October 6, 2021

Drainage Letter
Re: Sunset Village Filing 4 (1st Submittal)

DETENTION POND PLAN & DETAILS

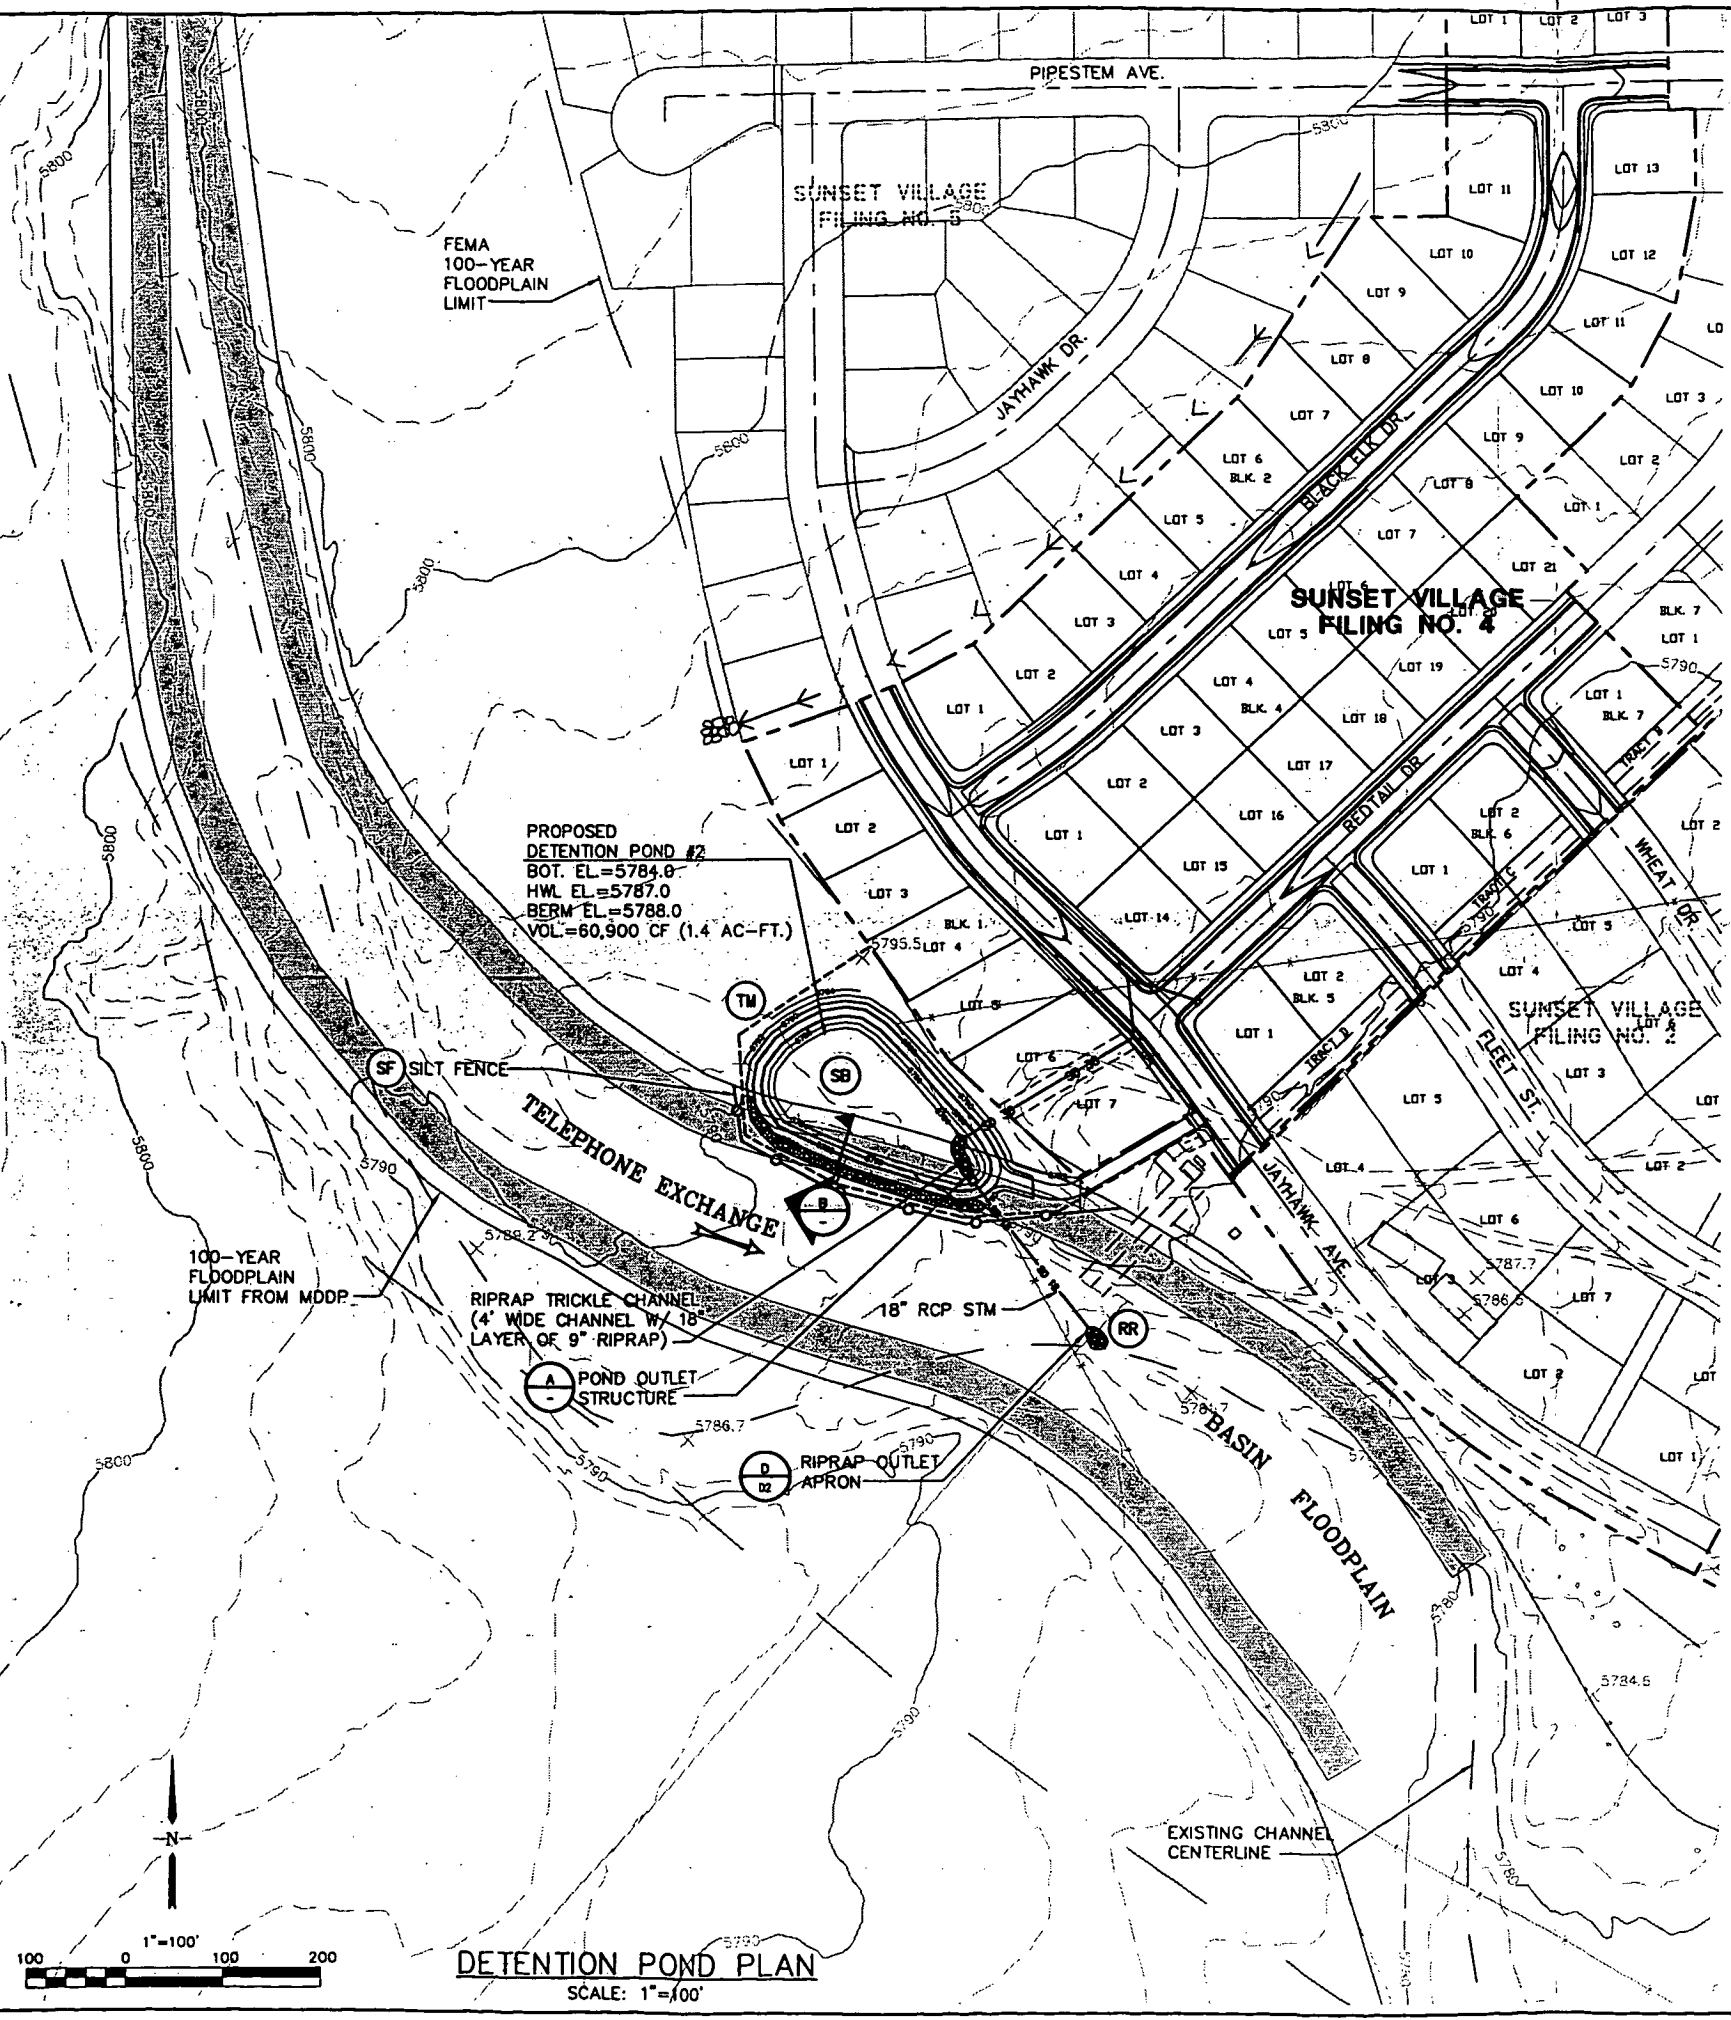
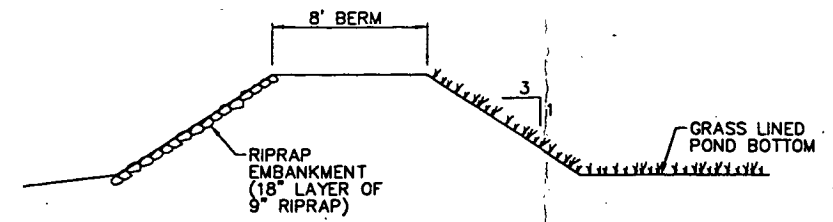
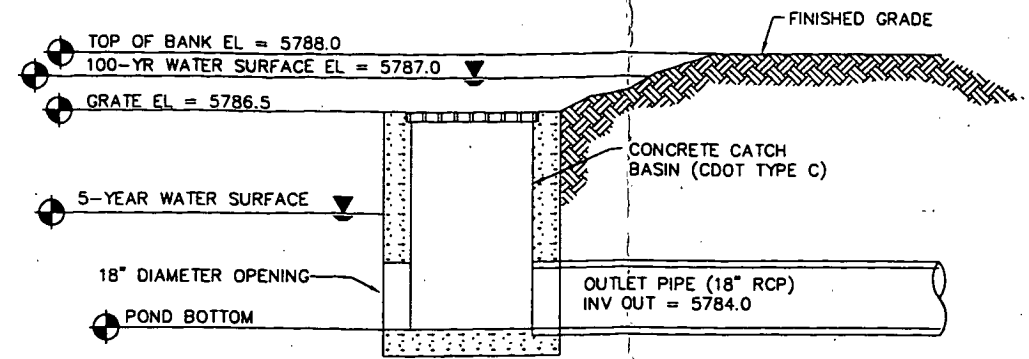
Update the existing and/or developed detention facility to describe the spillway design/condition. What is the existing condition and does the spillway need to be retrofitted? Explain the work needed if it needs to be retrofitted to meet current criteria.

Add a narrative explaining the pond outfall condition. Does it appear hydraulically stable? Are there proposed improvements needed?

The 2001 Construction Drawings include a Detention Pond Plan & Details sheet (D3) for the pond outlet structure and wall section design. The existing outlet structure was constructed according to this plan, however, current standards require that additional pond infrastructure be constructed in order for the Filing to be in compliance with El Paso County. The following is to be designed as supplemental plan set sheets within the original Construction Drawings:
